## PROPOSED LIDL FOODSTORE

Former Hayes Pool and Fitness Centre, Central Avenue, Hayes Town

Response to Highway Officer Comments

January 2016

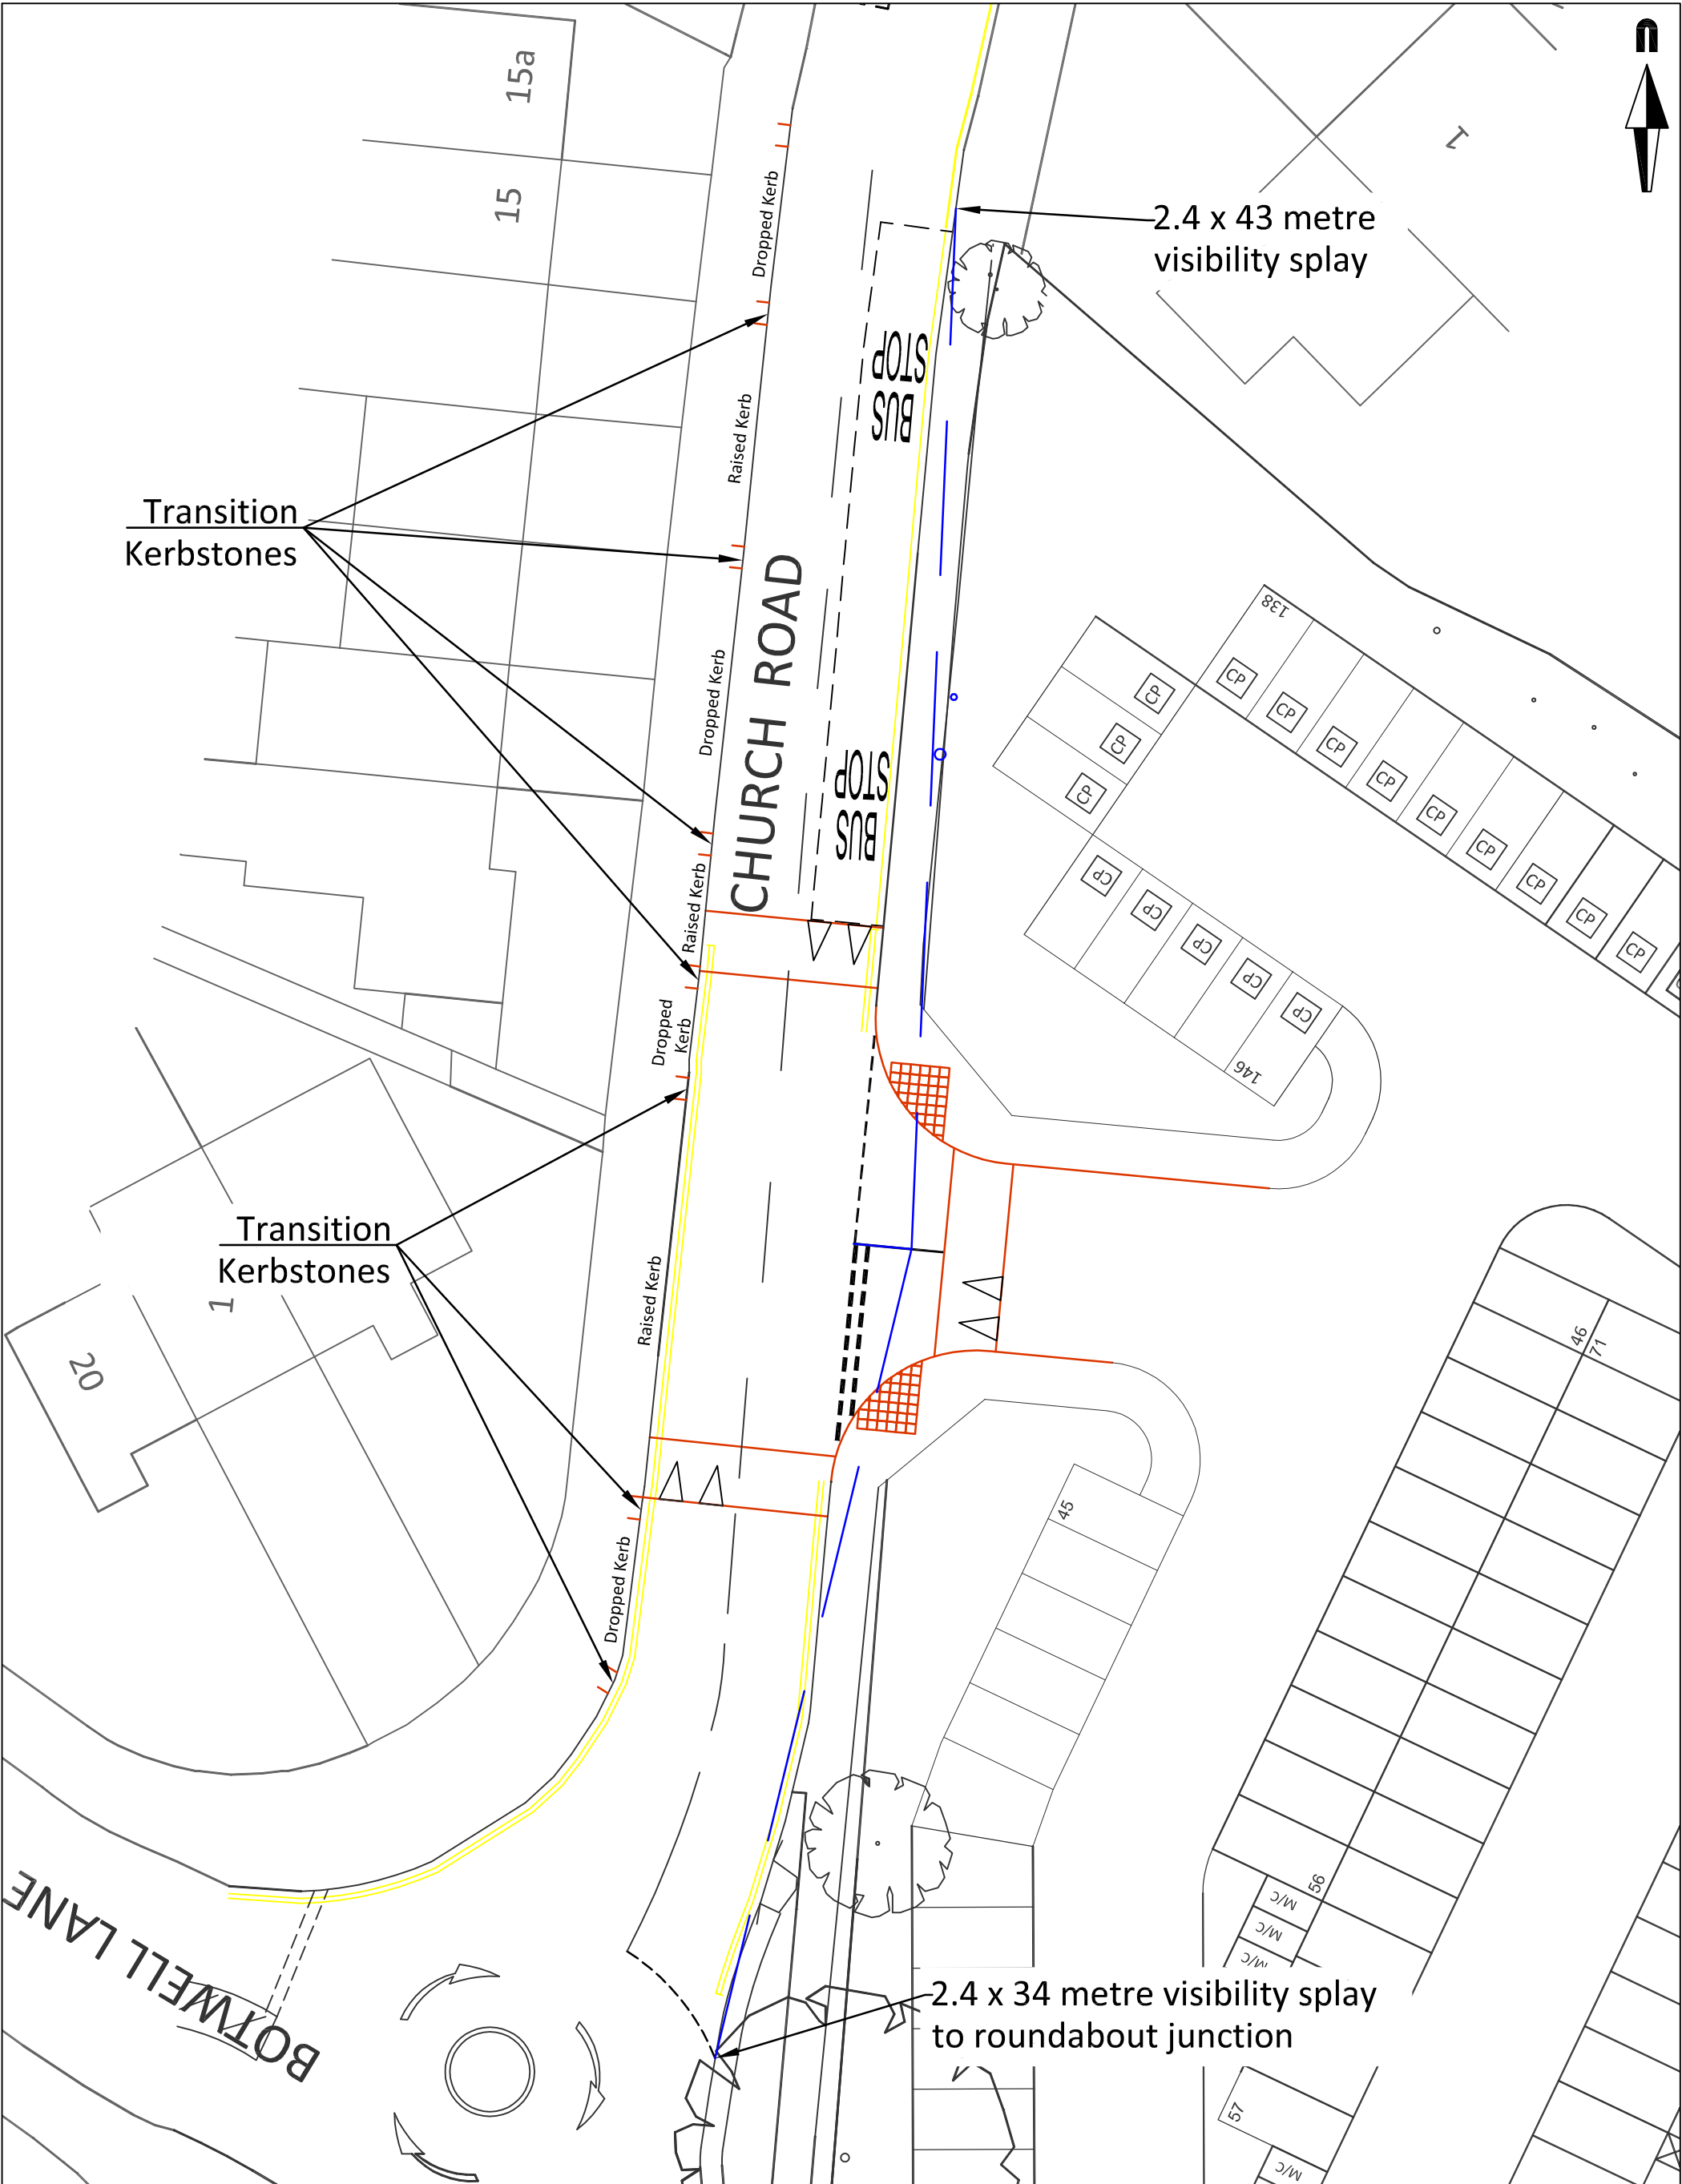
*“Location of the proposed access in close proximity to the bus stop and vehicle crossover opposite is unsatisfactory due to concern relating to sightlines and conflicting traffic movements.”*

- 4 To address the issues with visibility, two drawings have been created to provide the visibility splays associated with the proposed access arrangement. Drawing 15/0302/SK06, which is included at **Appendix A**, demonstrates the achievable visibility splays along Church Road, showing 2.4 by 43 metres to the north and 2.4 by 34 metres to the south, accounting for the proximity of the roundabout junction.

APPENDIX C
Site Access Junction - Extent of
Adoptable Highway

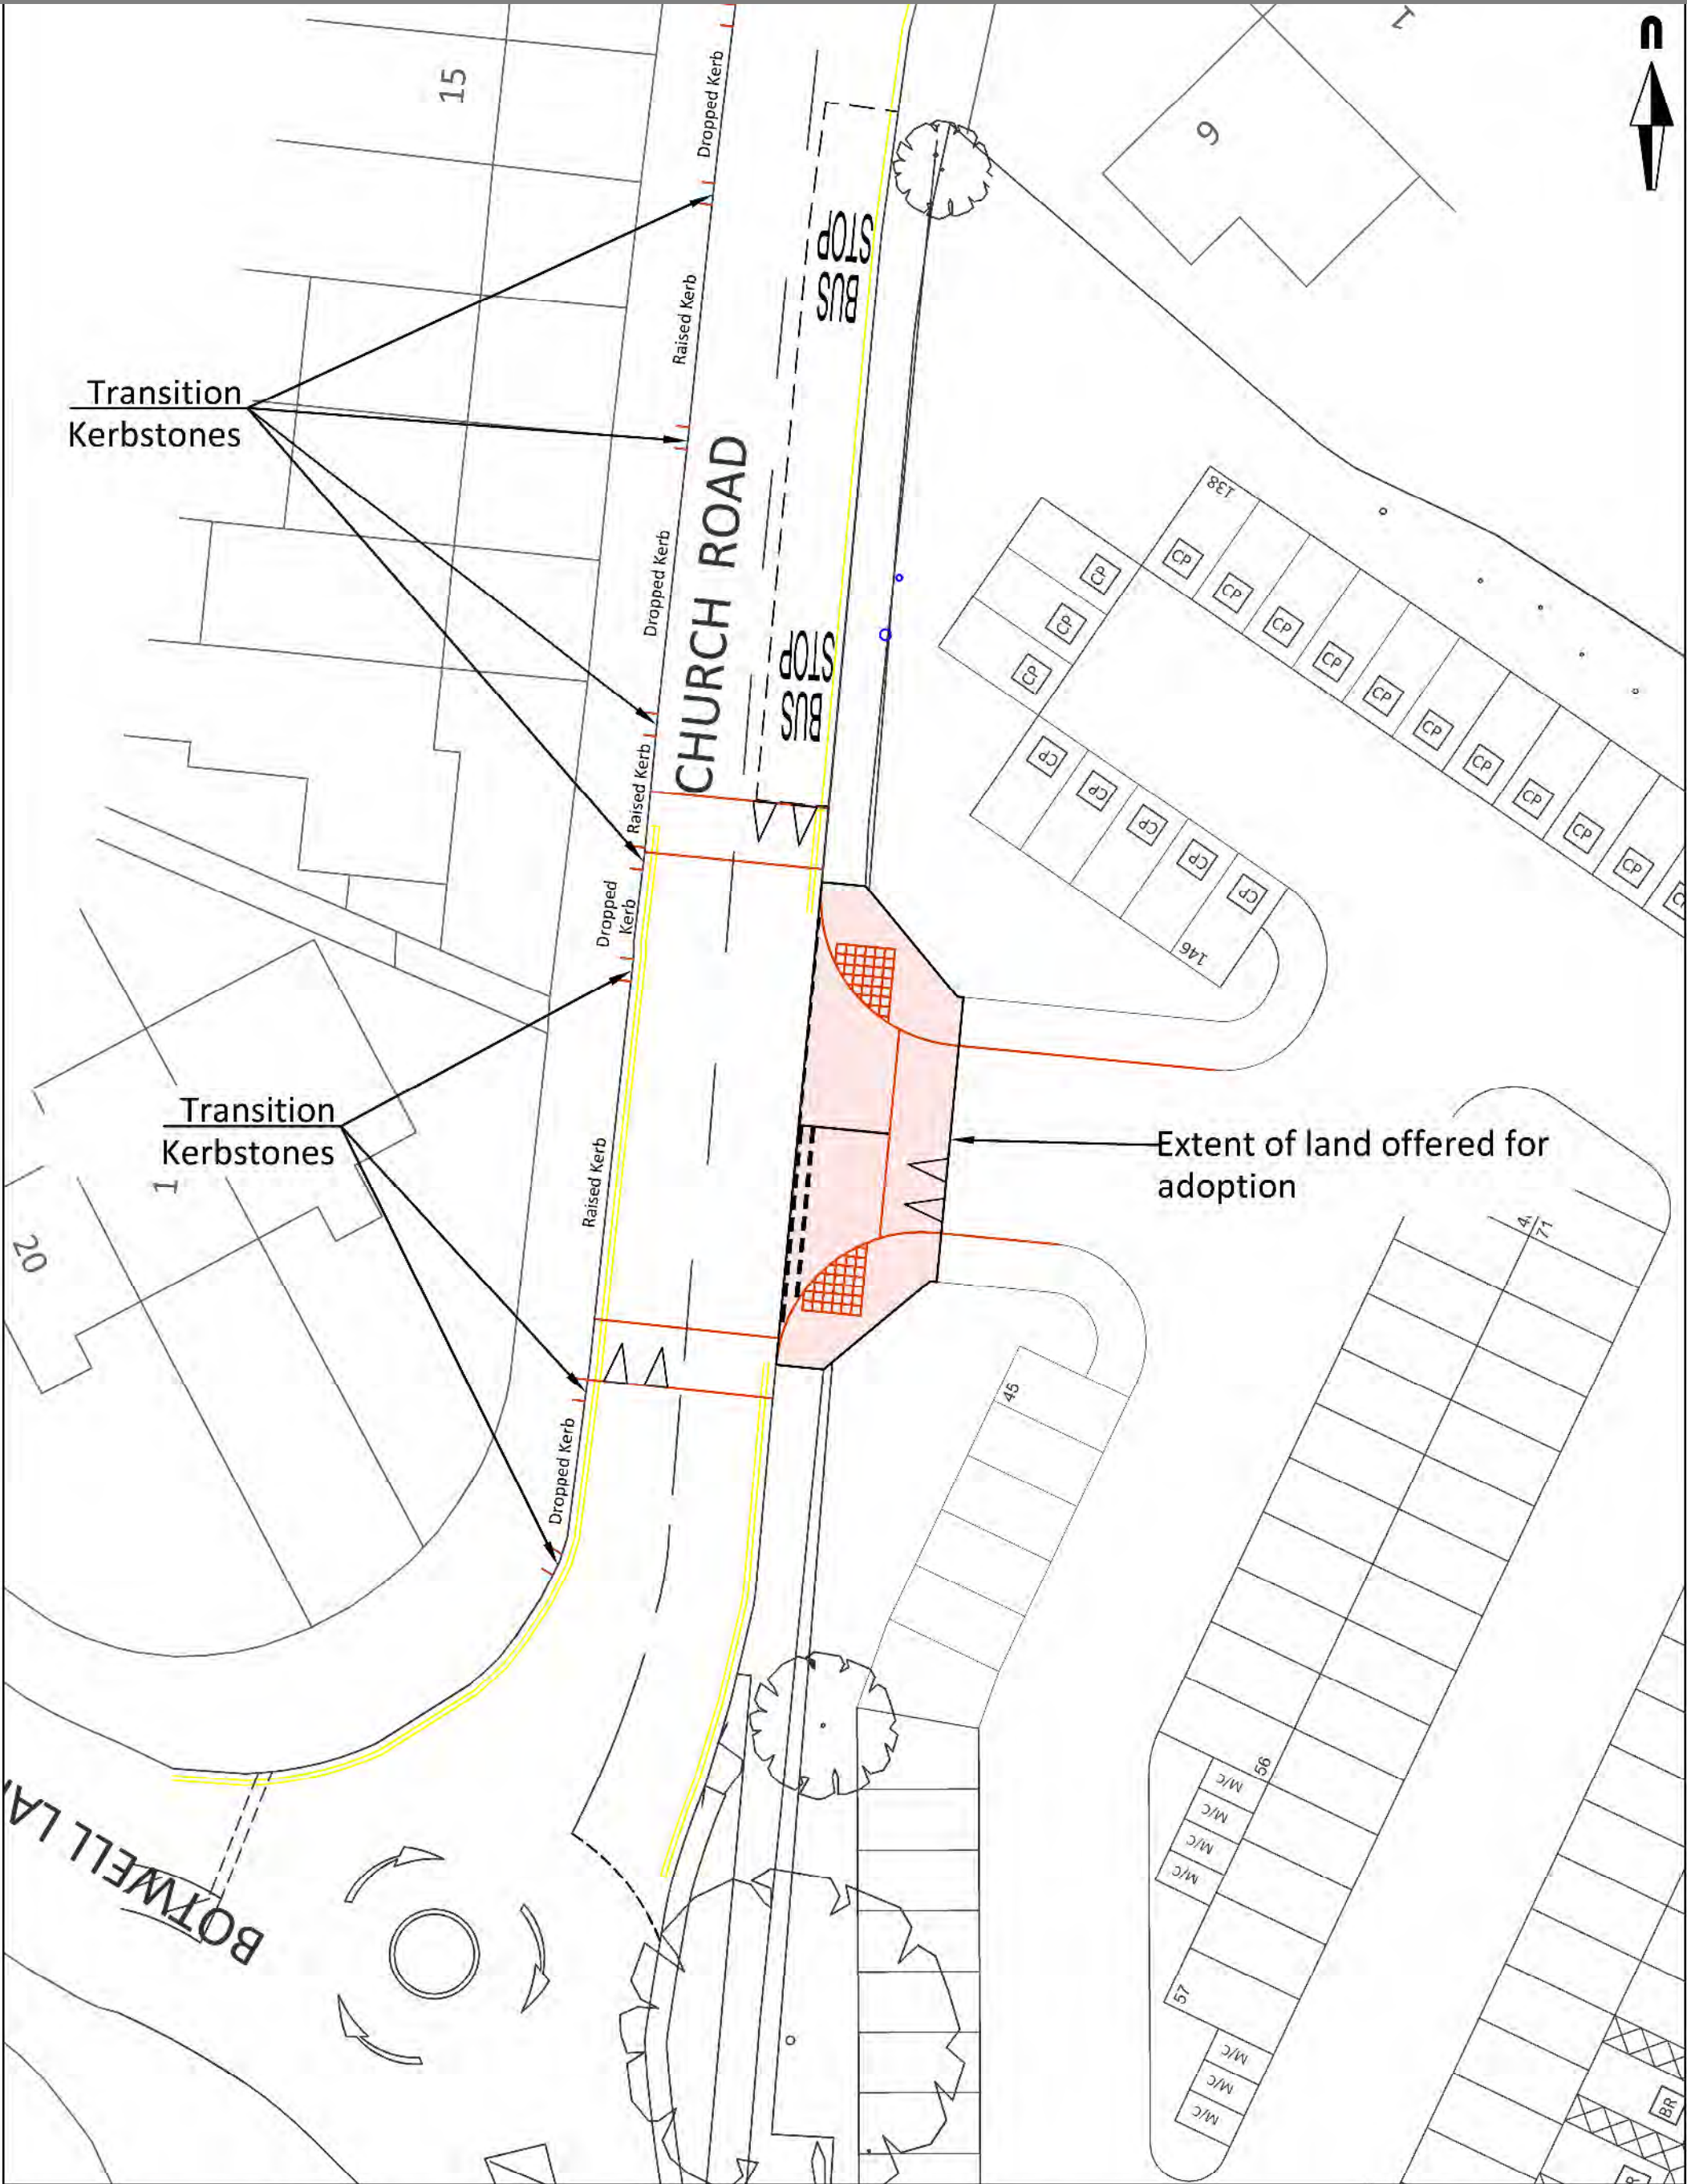
*“The extent of land offered for adoption at the proposed access should be clarified; ensuring safe pedestrian crossing facility and surface drainage from private and public land are adequately addressed. “*

- 12** It is considered that the extent of land offered for adoption would cover the entire raised table and ramp within the Lidl site. This is illustrated in an adoption extent drawing, included at **Appendix C**, which highlights the adoption boundary in red.
